STATE OF NORTH CAROLINA DEPARTMENT OF TRANSPORTATION

Addendum No. 1

RE: Contract # C204554 WBS # 46032.3.2 FEDERAL-AID NO. BRZ-2044(4) **Wake Counties (B-5318)** BRIDGE #126 OVER SMITH'S CREEK ON SR-2044 (LIGON MILL RD) IN WAKE FOREST

The following revisions have been made to the Structures plans.

REVISIONS						SHEET NO.
NO.	BY:	DATE:	NO.	BY:	DATE:	S-1
1			3			TOTAL SHEETS
2			4			41

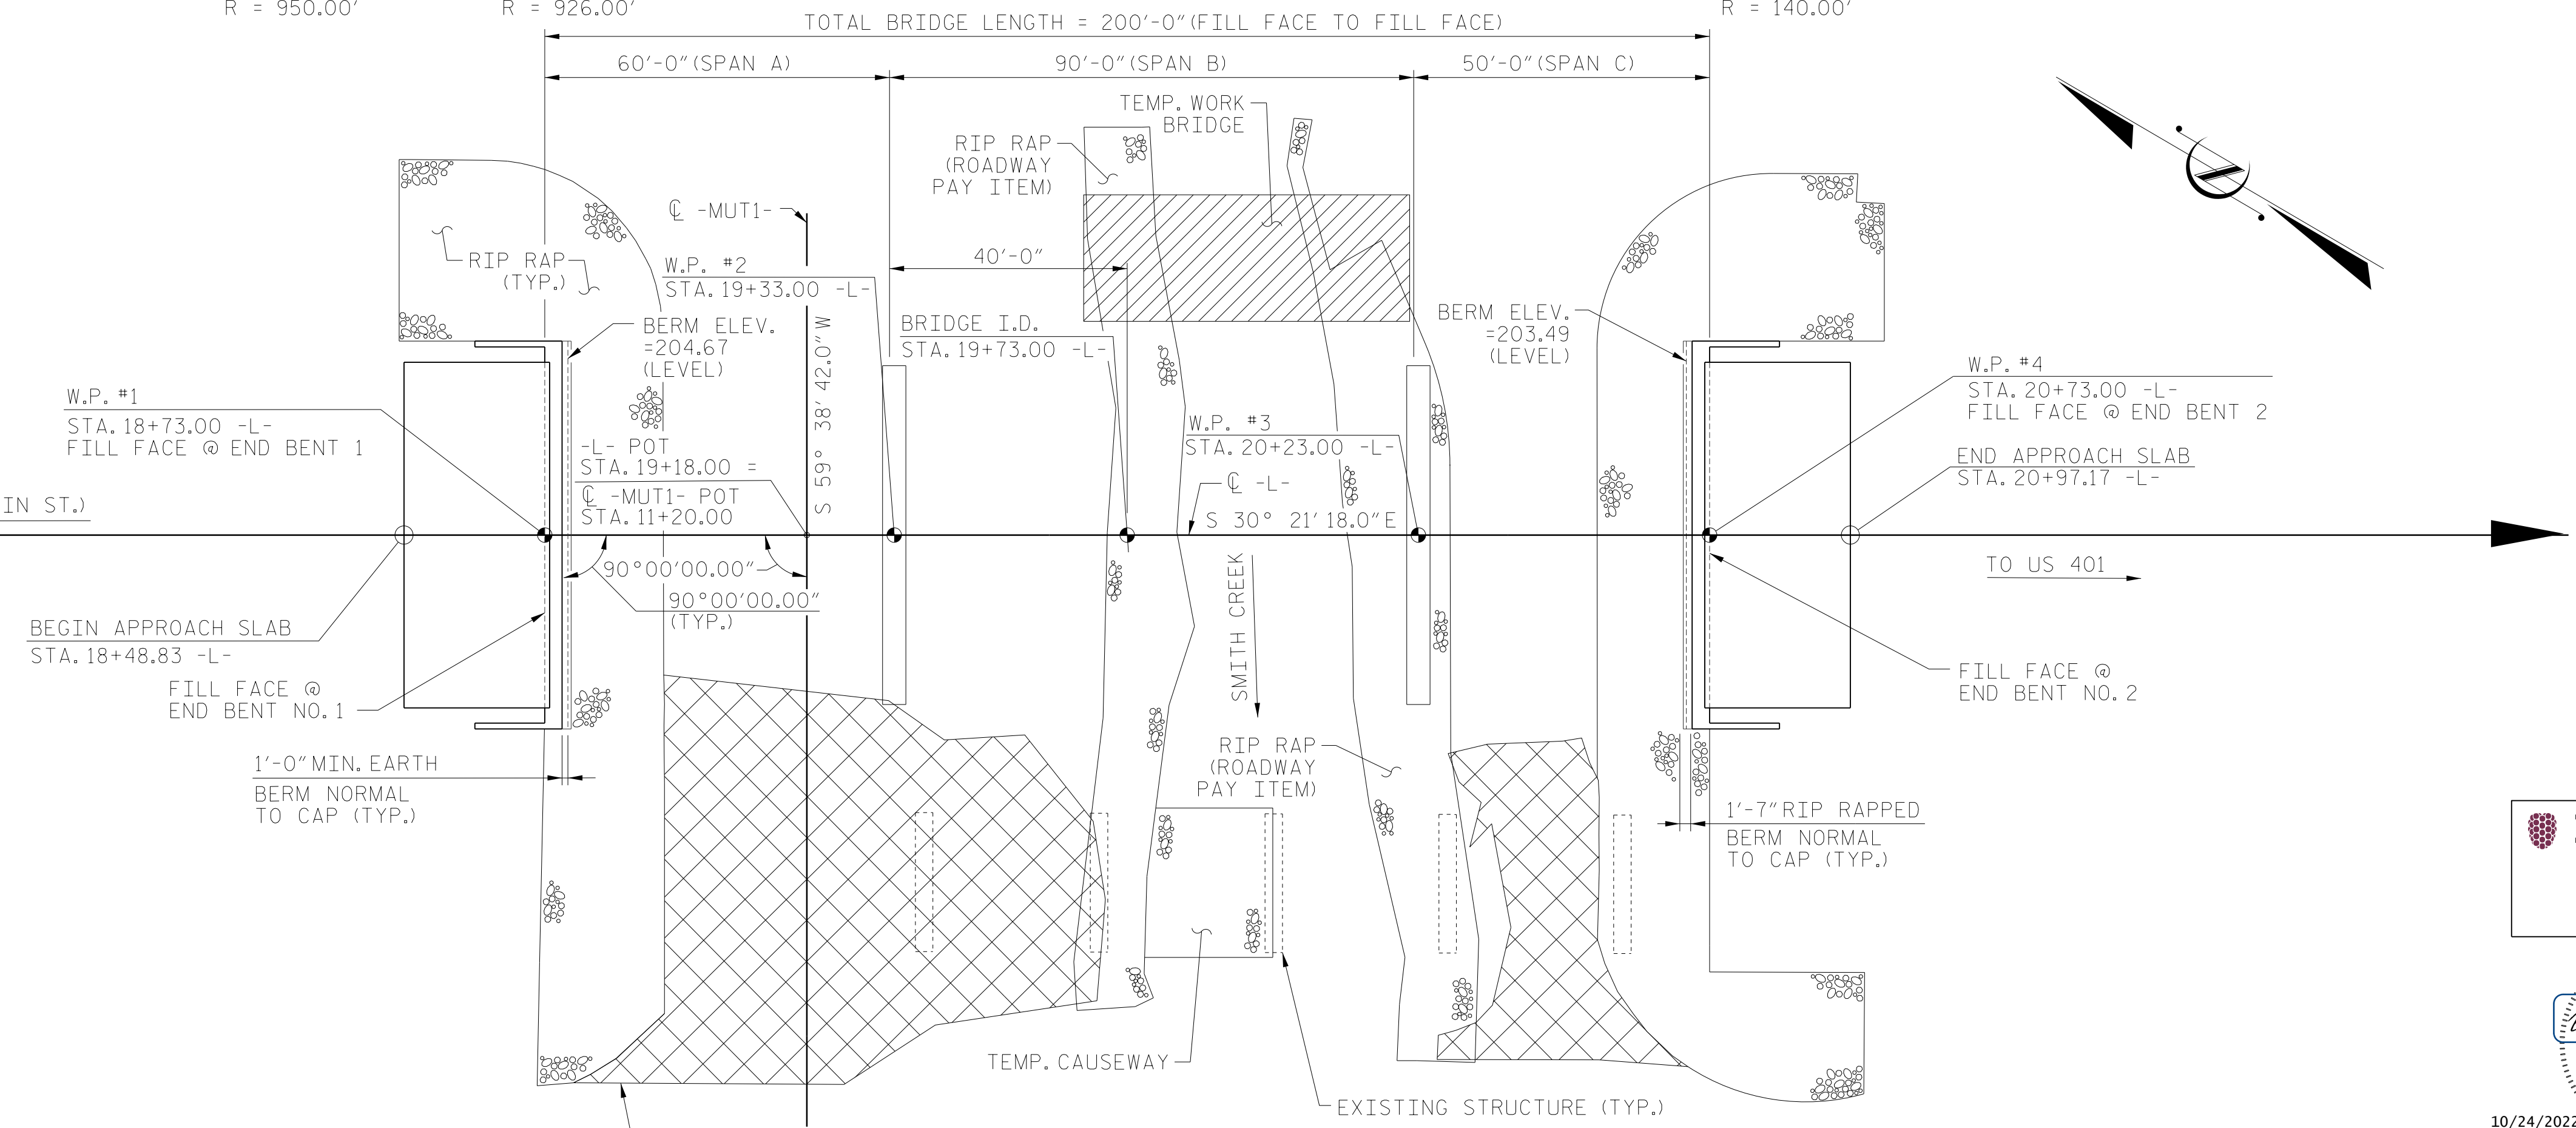
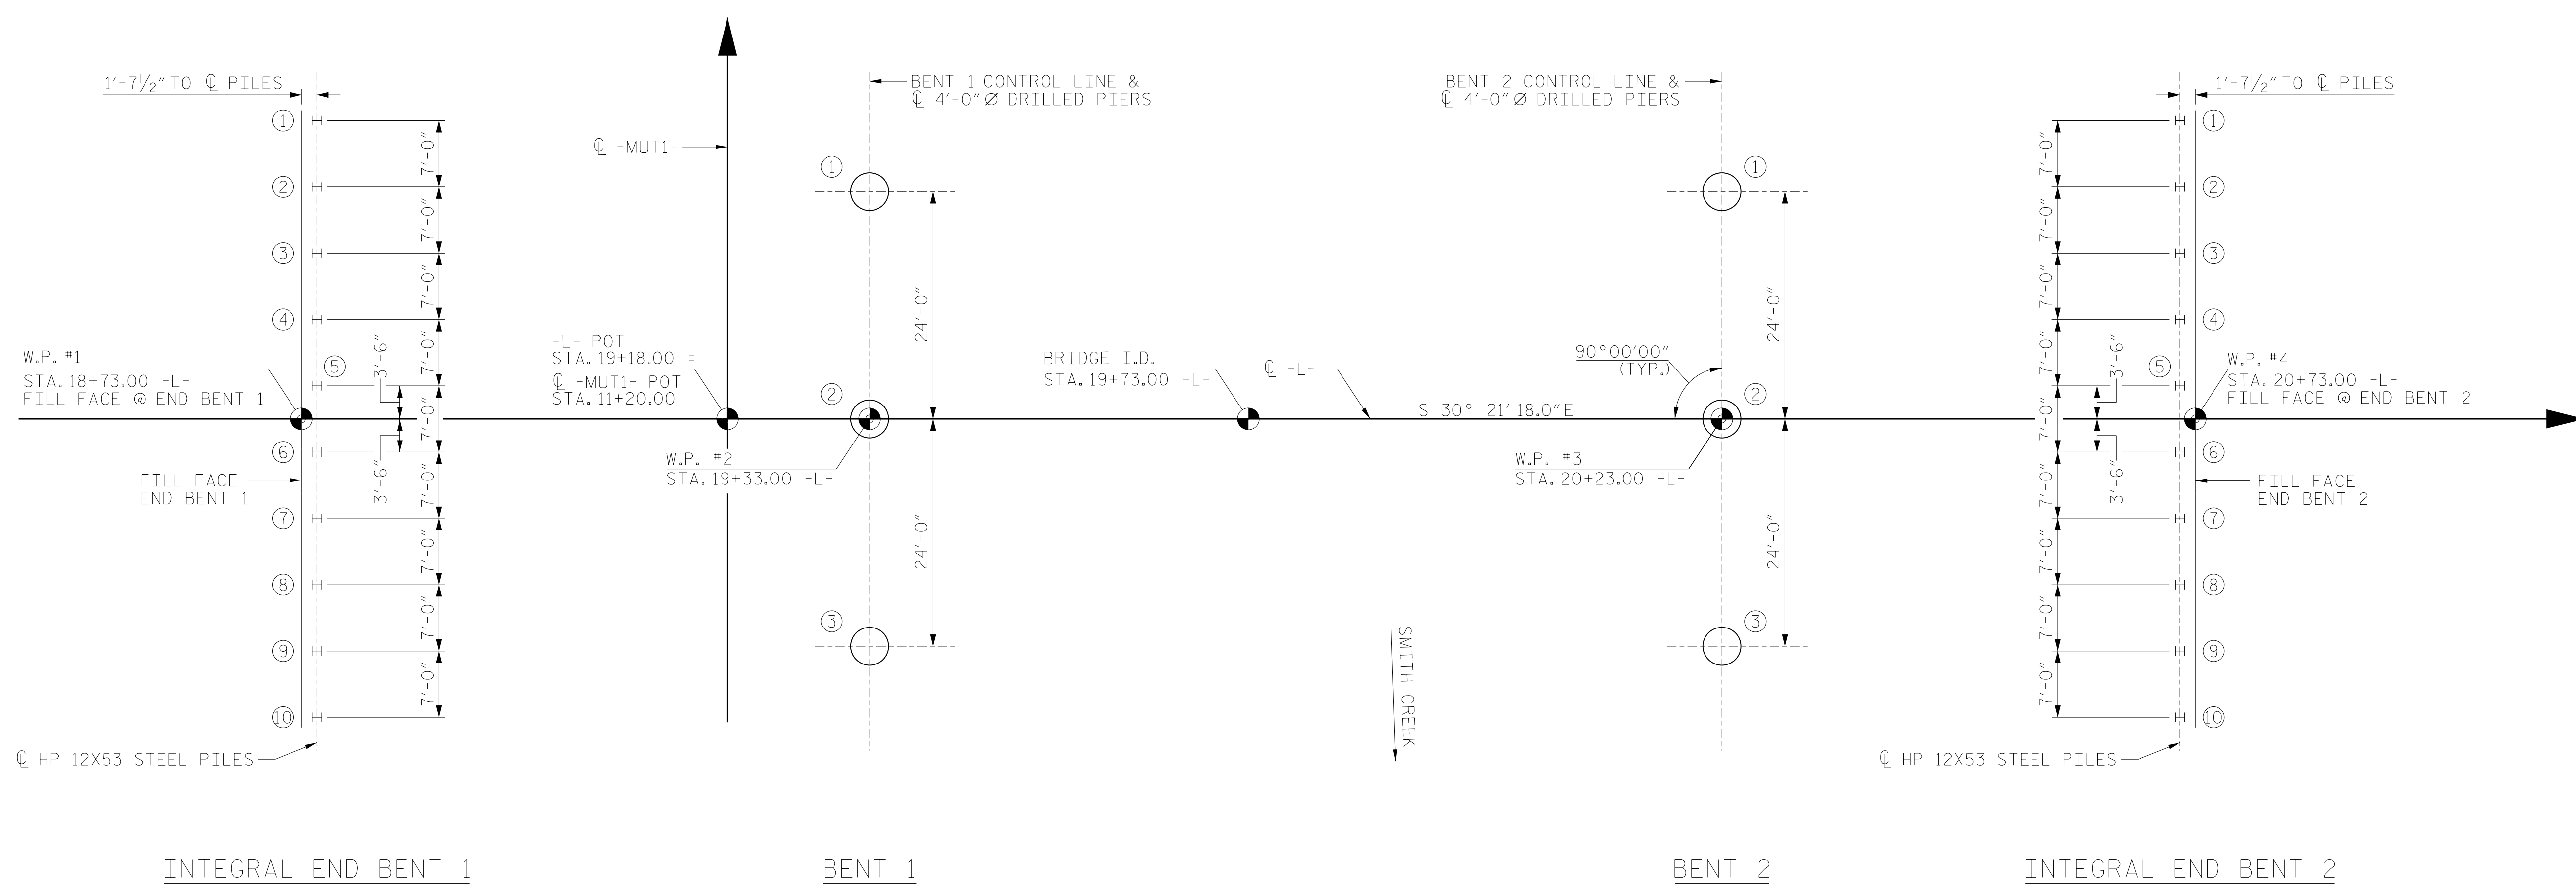
Sheet No.	Revision
S-1	Revised to show the temporary work bridge location.
S-3 (New)	"Pile and Drilled Pier Foundation Tables" plan sheet added.
